4-Way Commercial Phase 1
Site Development Plan
Traffic Impact Analysis
PCD File No. PPR2347
(LSC #S224452)
January 27, 2026

6/17/2026
LSC Responses
to EPC TIS Redline
Comments

RE: 4-Way Commercial
Site Development Plan
El Paso County, CO
Traffic Impact Analysis
PCD File No.: [PPR2347](#)
LSC #S224452

Figure 2
Site
Plan

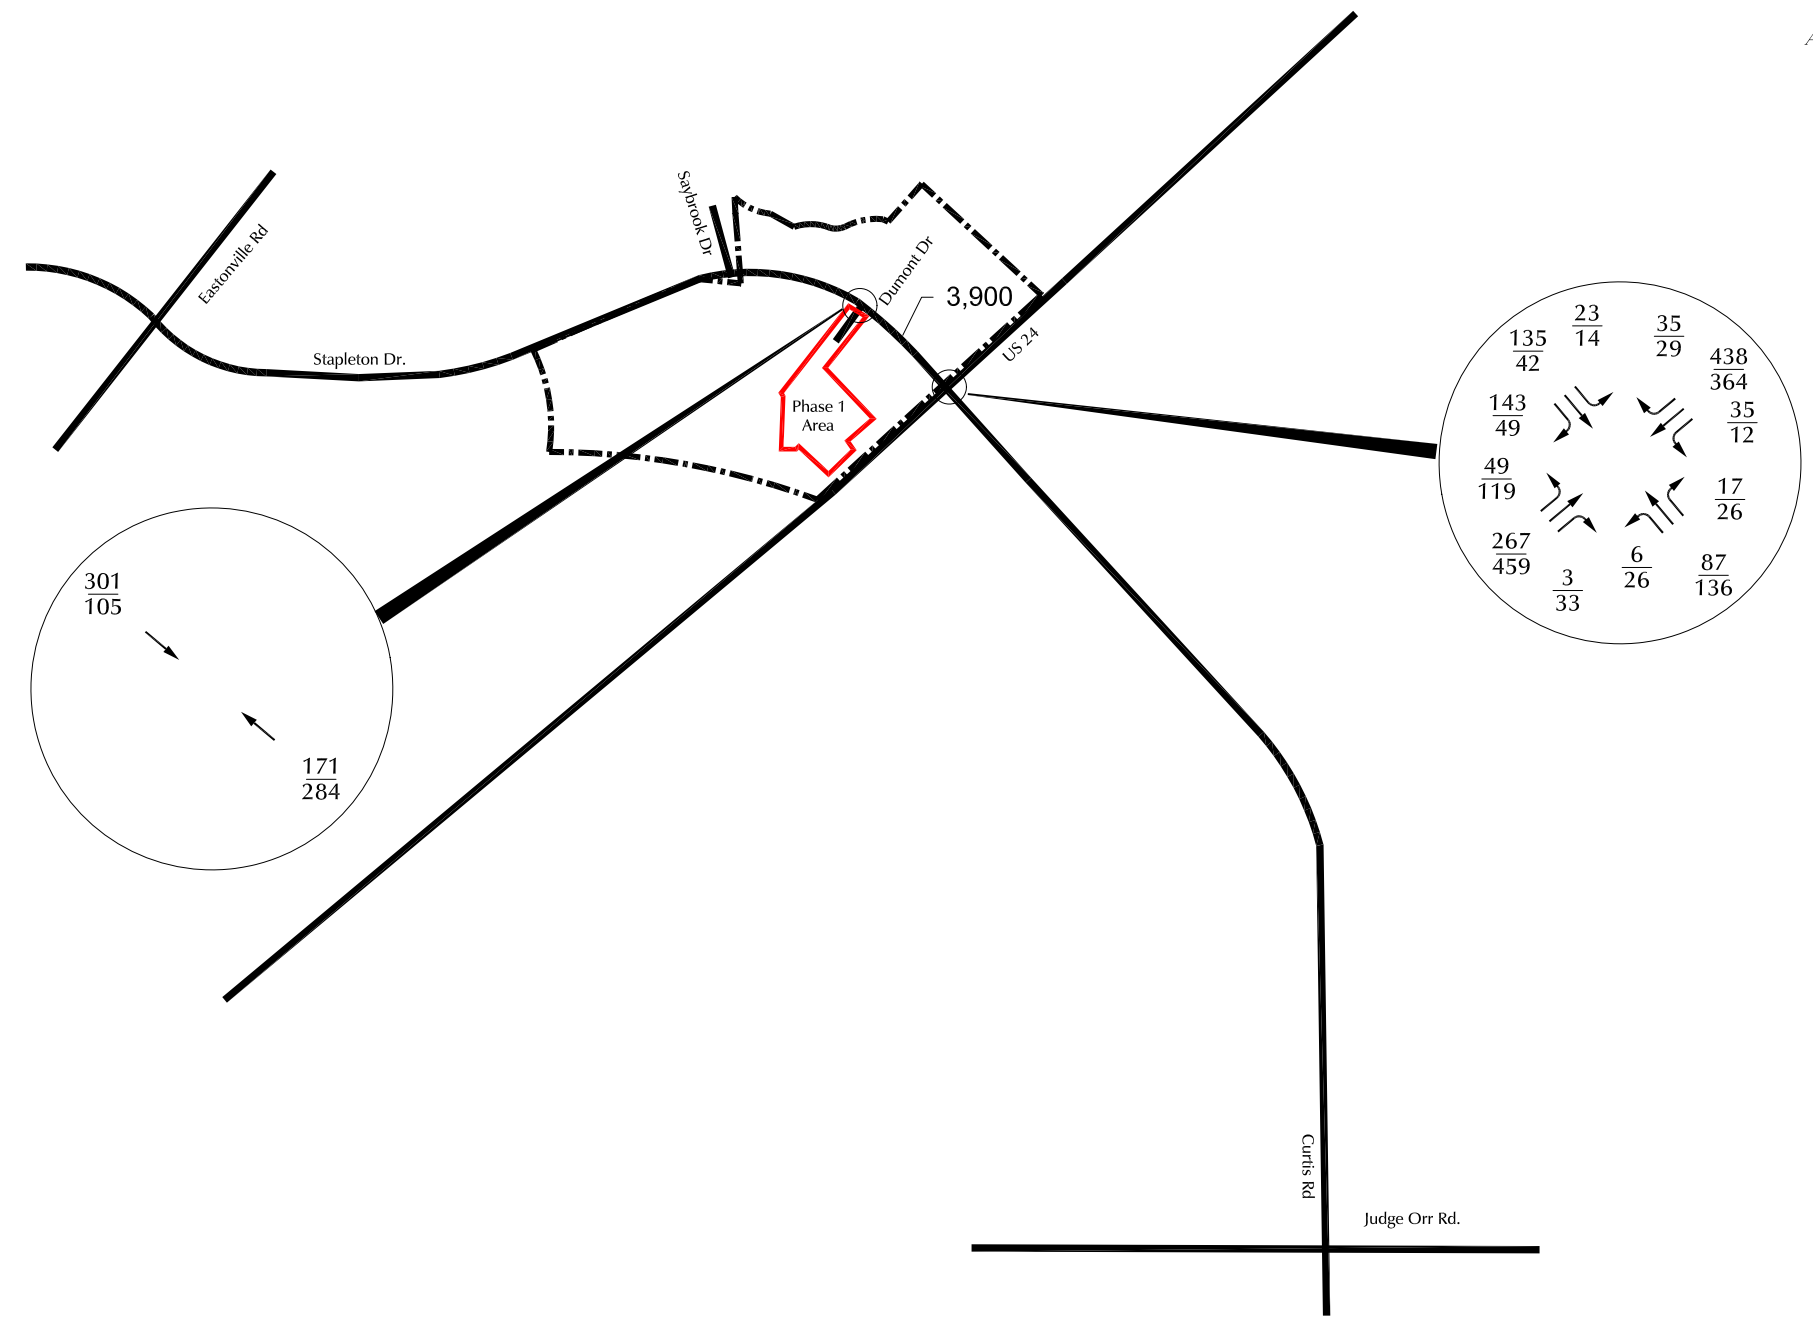
multi-family is indicated in the figure. Please revise.

LSC Response: The figure has been revised to clarify that townhomes are the anticipated land use for Area 4
